Application for Planning Permission for Works or Extension to a Dwelling

Development: Proposed oak framed carport to northern end of existing dwelling.
Location: Longacre Maypole Lane Yapton BN18 0DR

I regret that I am unable to accept your documents as a valid application until the following item(s) have been received or resolved :-

EXISTING PLAN AND ELEVATIONS

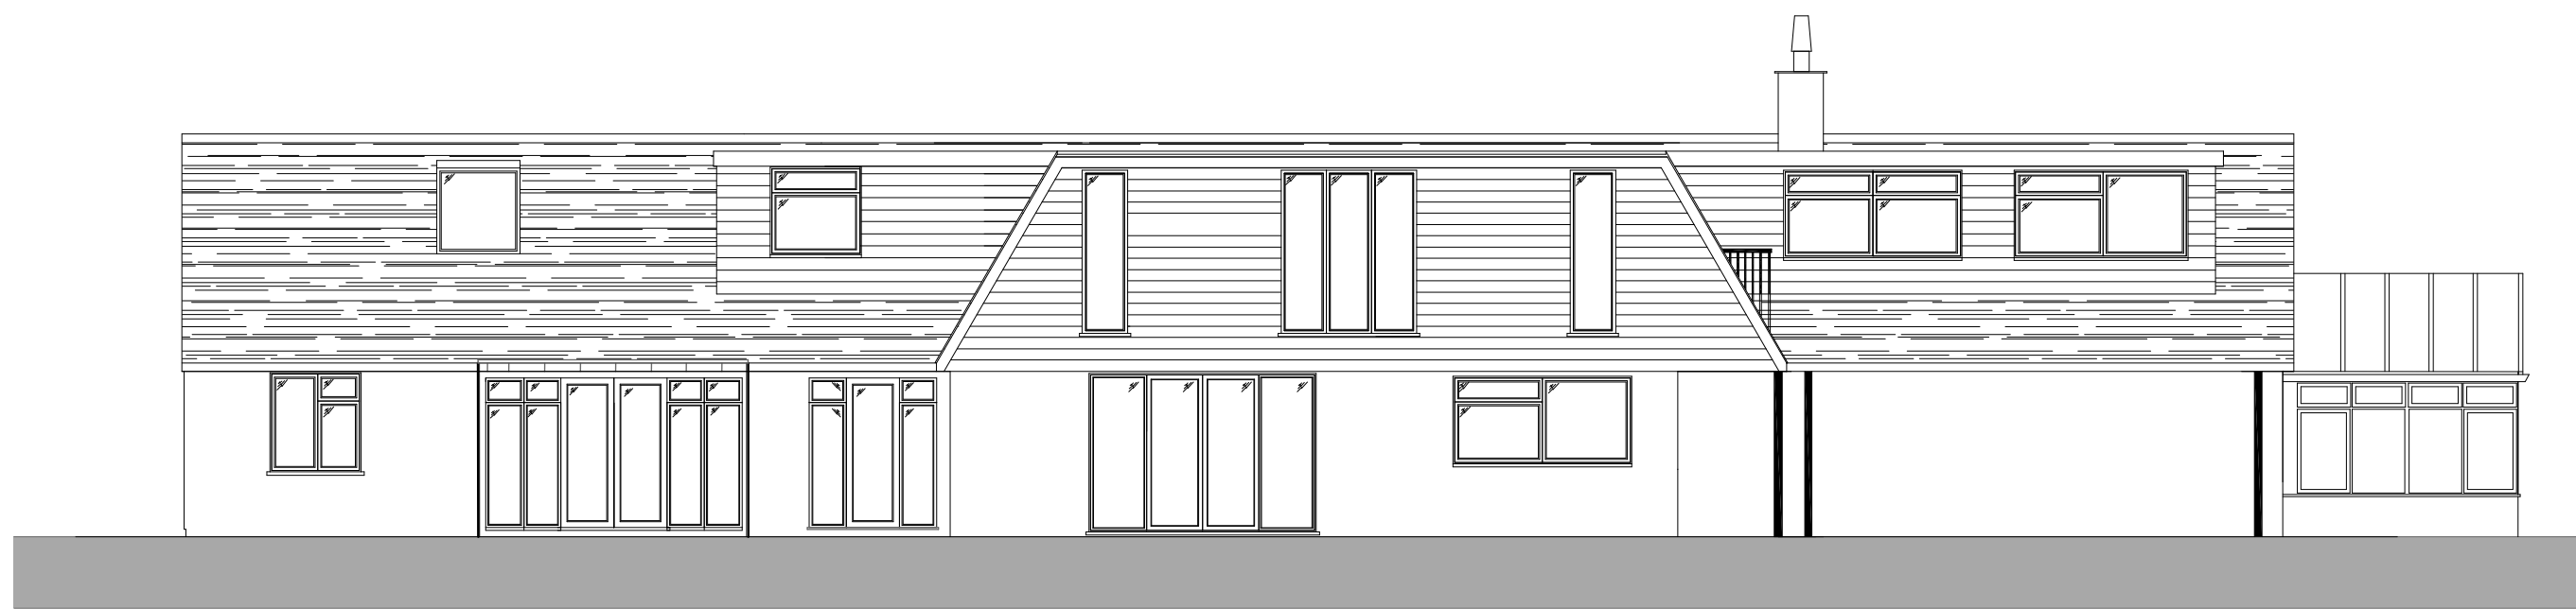
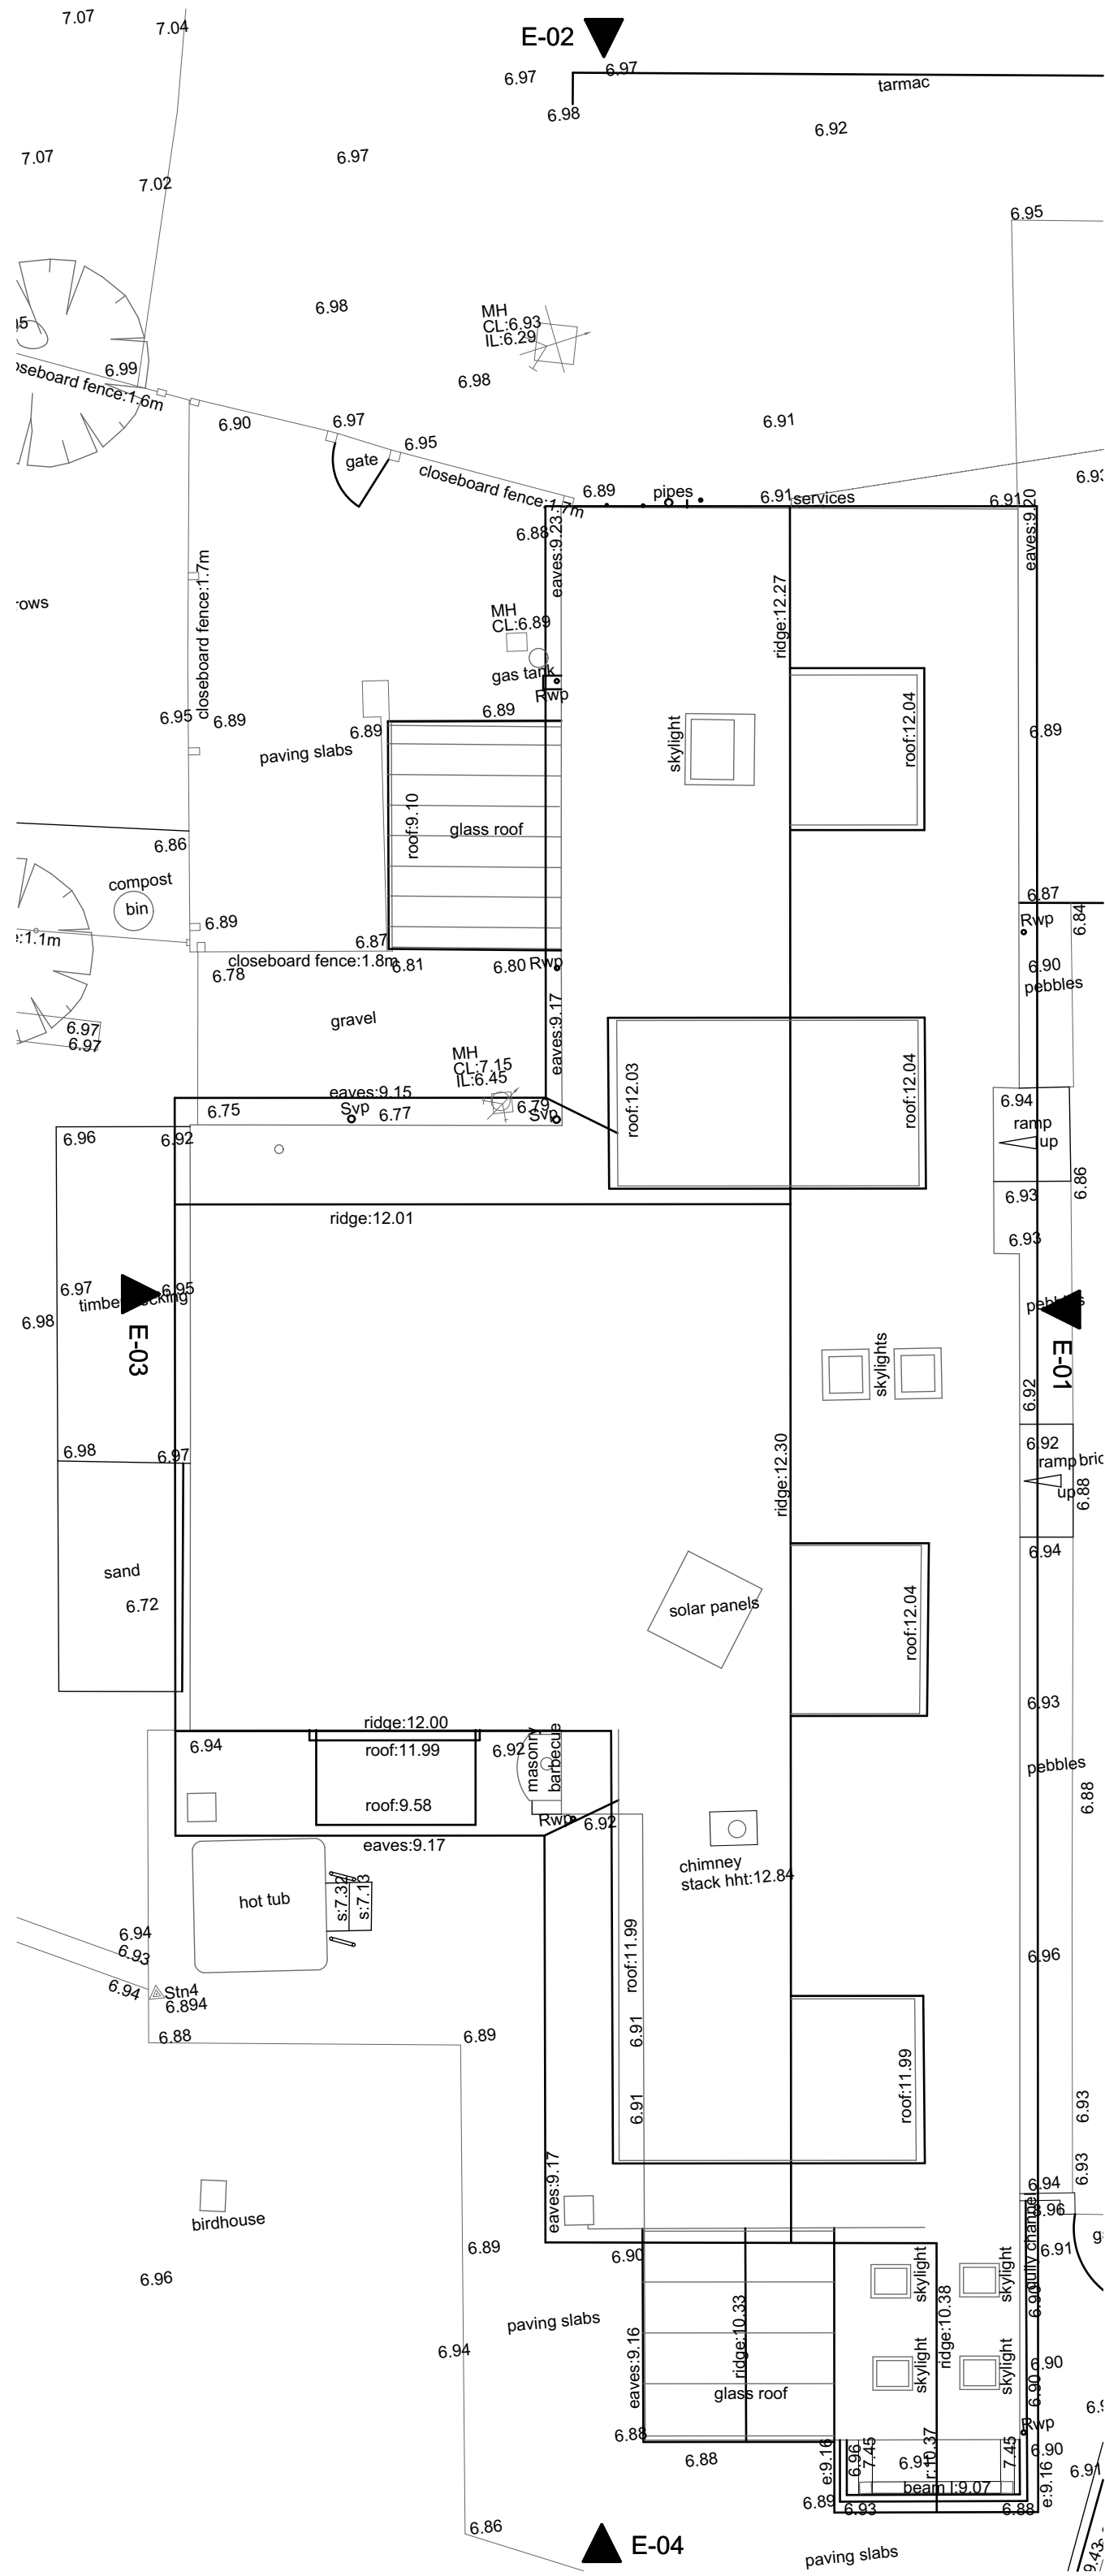
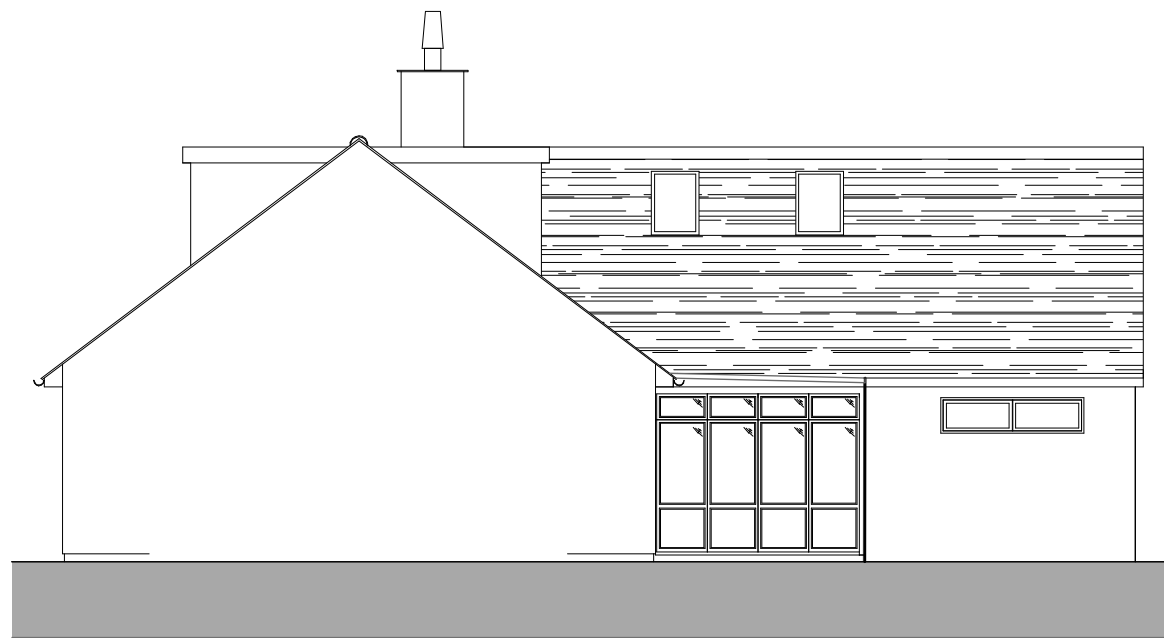
Existing Elevations

The existing elevations have not been submitted correctly, the drawings are partly missing, please review and resubmit.

EXISTING LOCATION & BLOCK PLANS

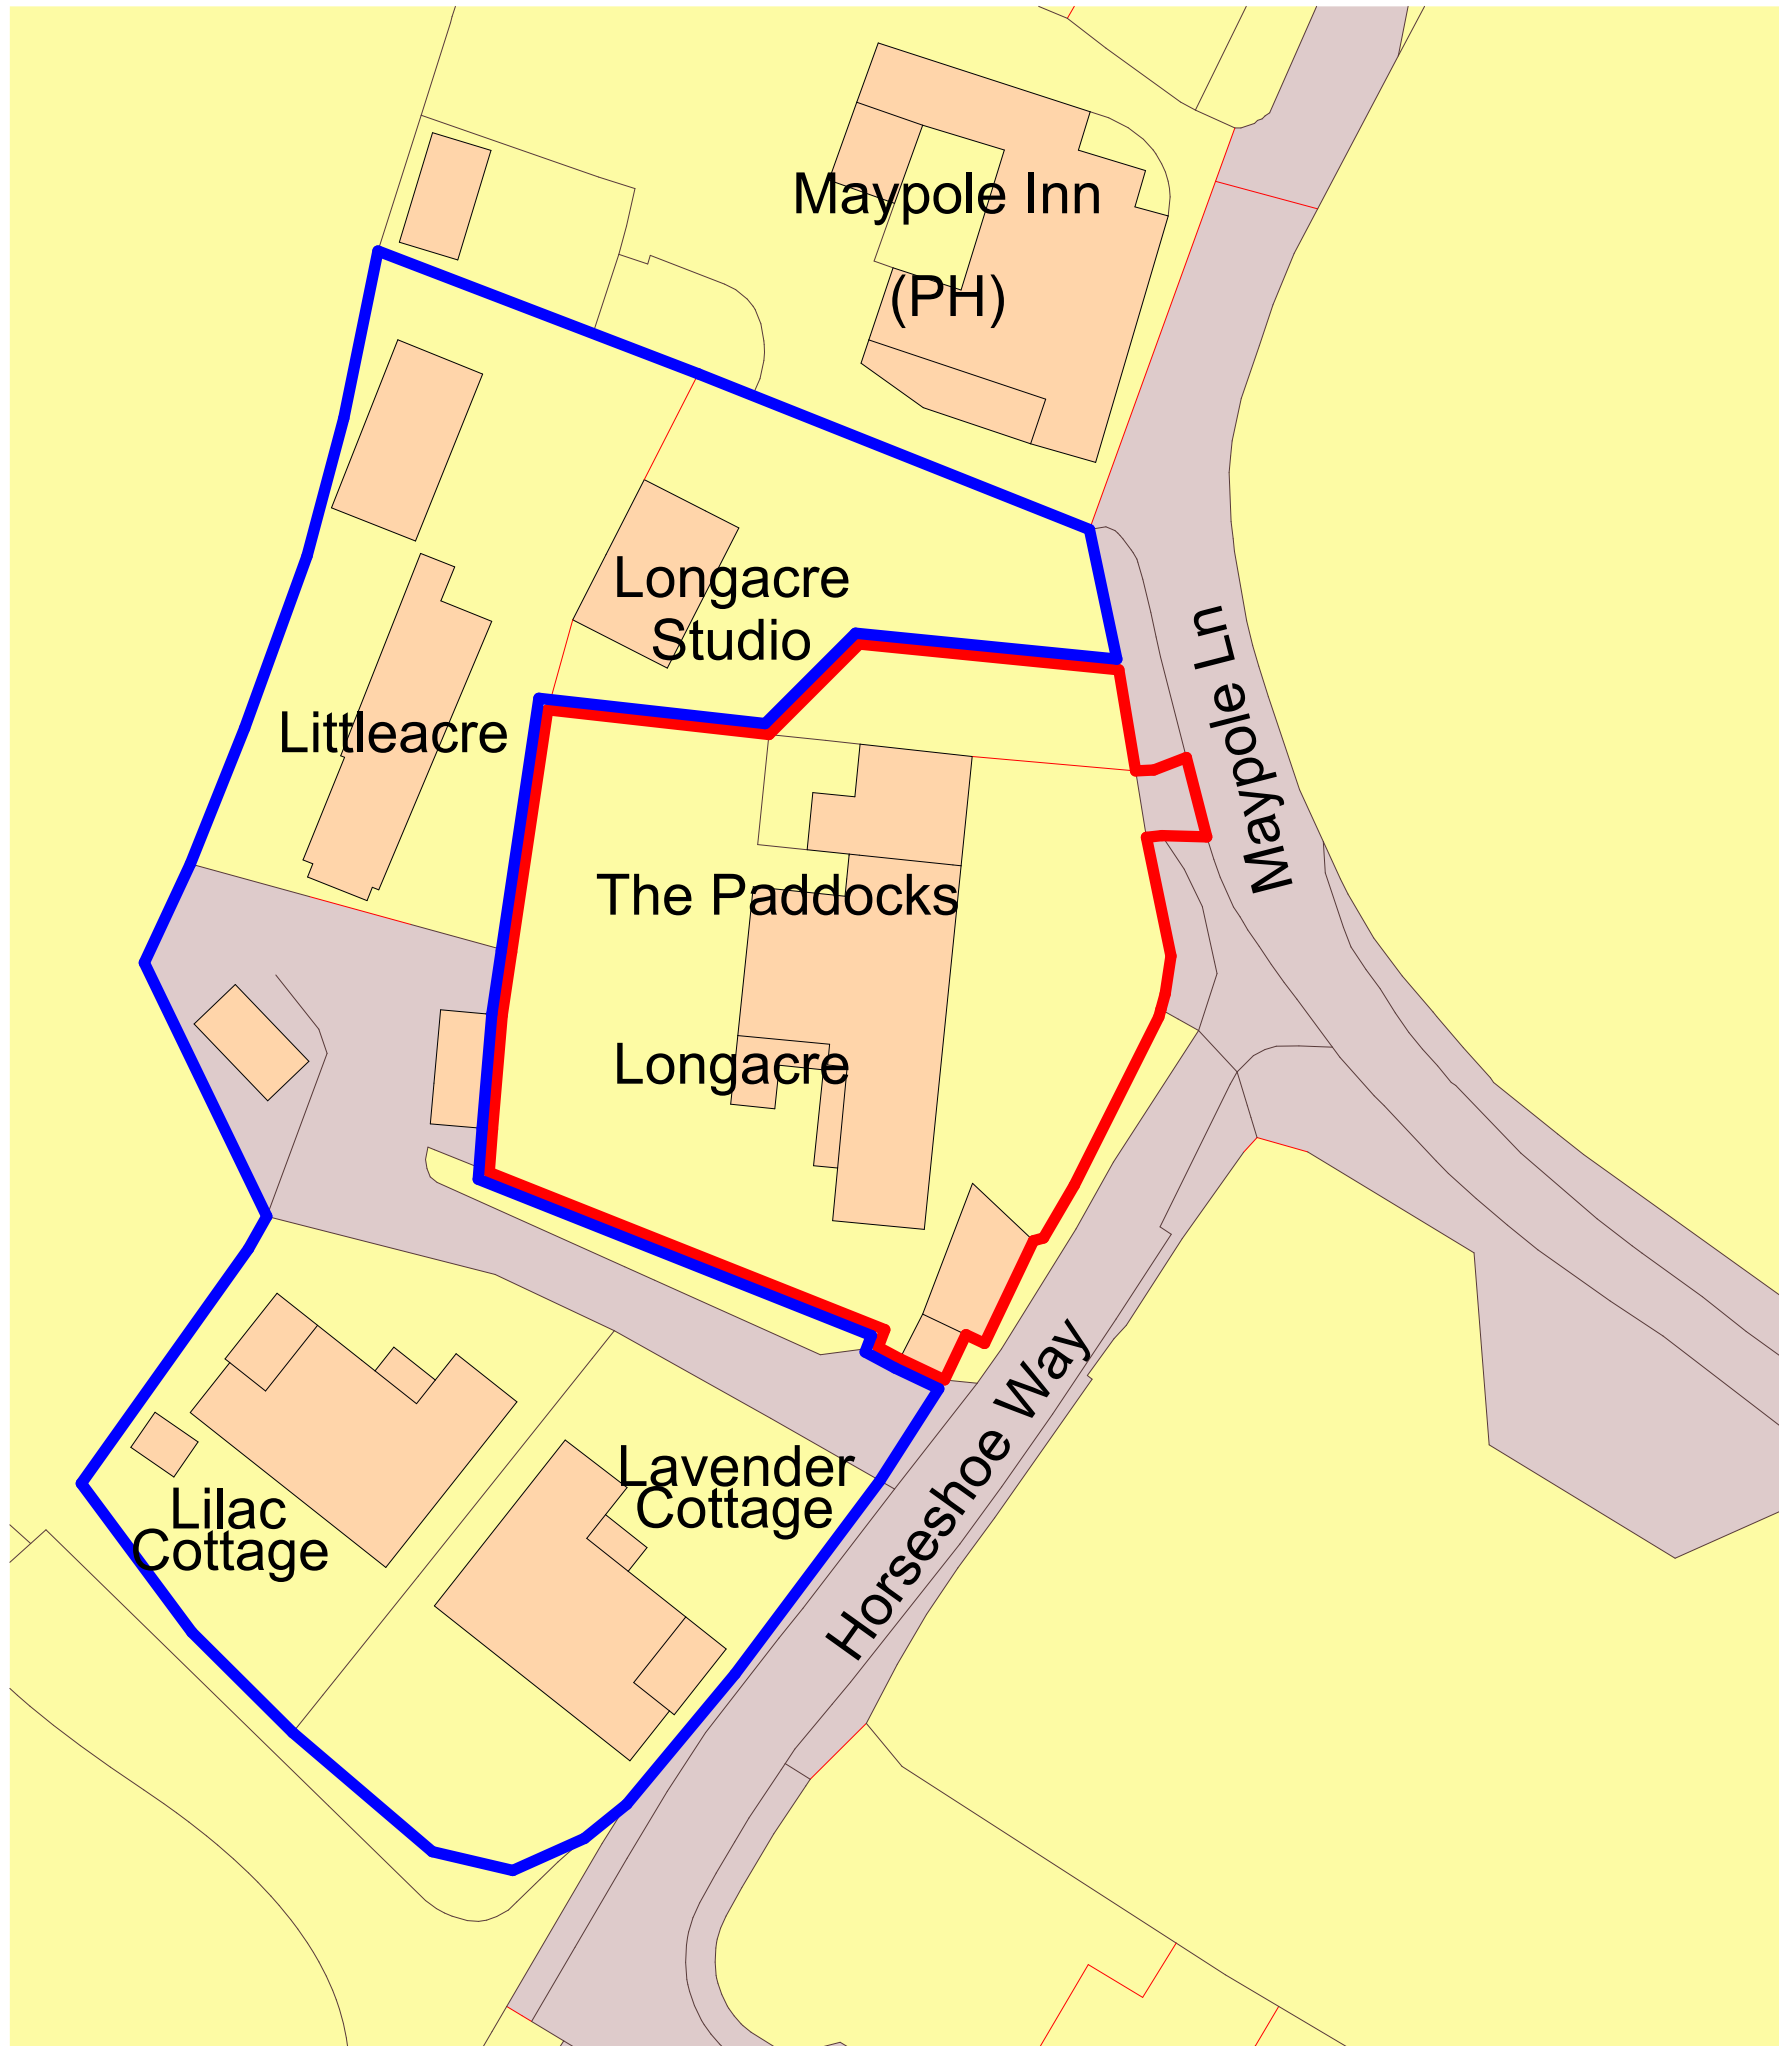
Please add a north arrow to the location plan.
